RE: HIGHVIEW FARM

Metis have completed their second review of application 39755/APP/2023/652 - Highview Farm, Newyears Green Lane. Please refer to the comments below.

S05 PROPOSED SECTION AT SOUTH SIDE OF SITE THROUGH PROPOSED BUND
SL601 1:50 @ A1

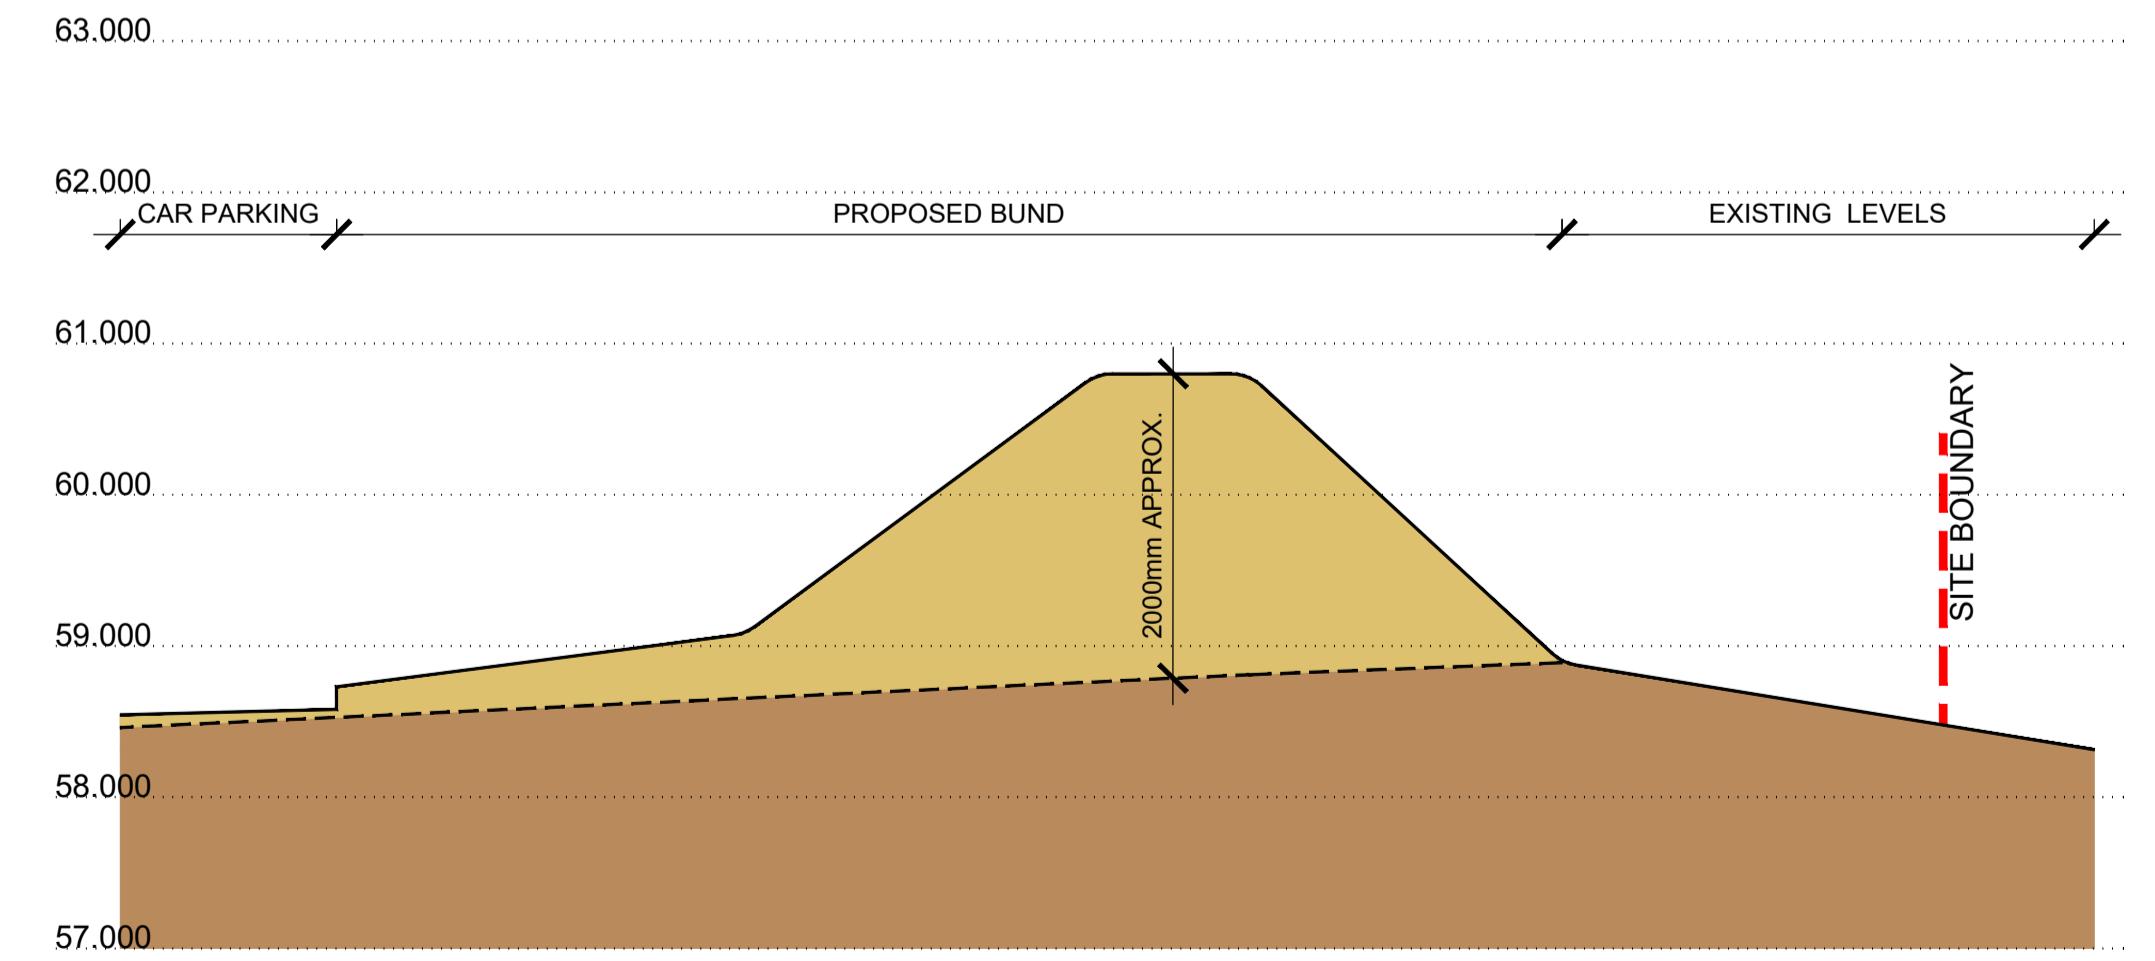
- The applicant has not confirmed what the storage volume of 10,000m³ in the calculations includes, as only 2,297m³ has been stated as being proposed within the water tanks and bunds.

The storage includes c.2,297m³ in the tanks and c.7,703m³ on the surface of the hardstanding behind the site bunding, which is approx. 3m high. This is to show that the 1in100+CC storm event can be stored with no offsite flooding. The water would be spread onto the compost as confirmed previously. It is also worth noting that the site bunding prevents over 22,900m³ of volume from leaving site.
